# ENG-SF20015-R2-FDR-redlines.pdf Markup Summary

Engineering Review  
dsdrice@epc.com  
JedRice@epc.com  
(714) 938-7977  
EPC Planning & Community Development Department

STRM_24 PROFILE
STA 0+00.00 TO 2+50.00
PRIVATE (SRMD)

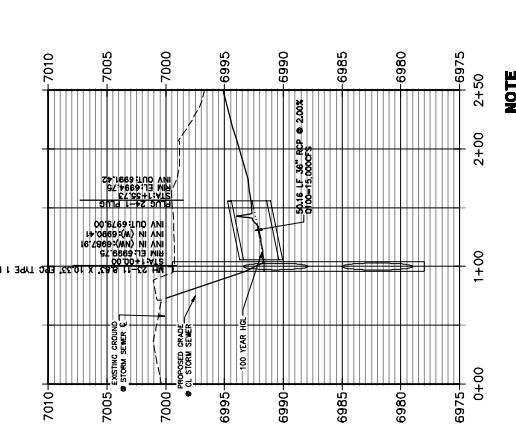
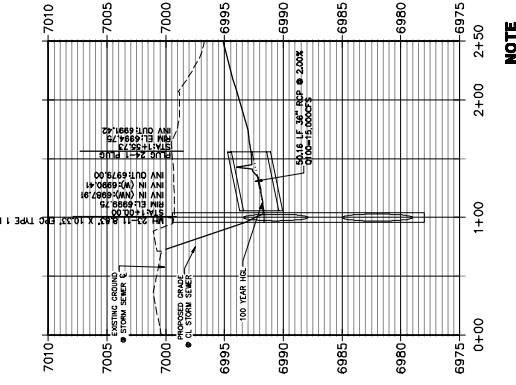
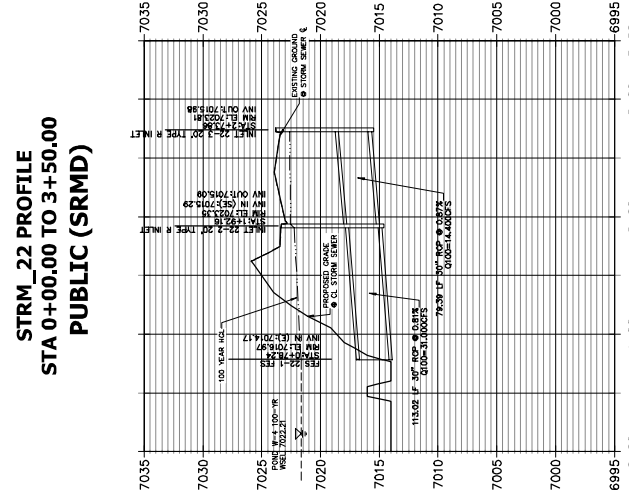
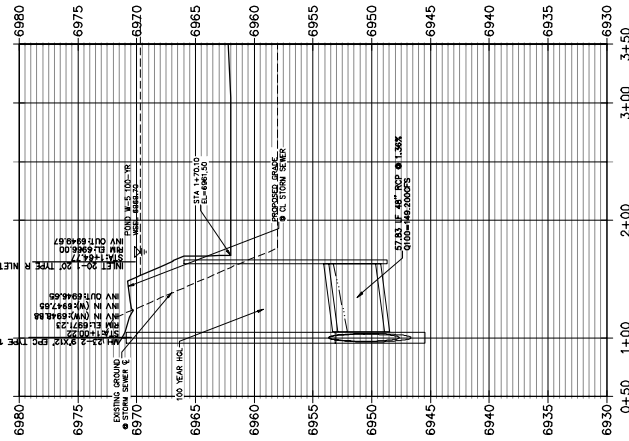
Are these over  
capacity? Are  
watertight joints  
required?
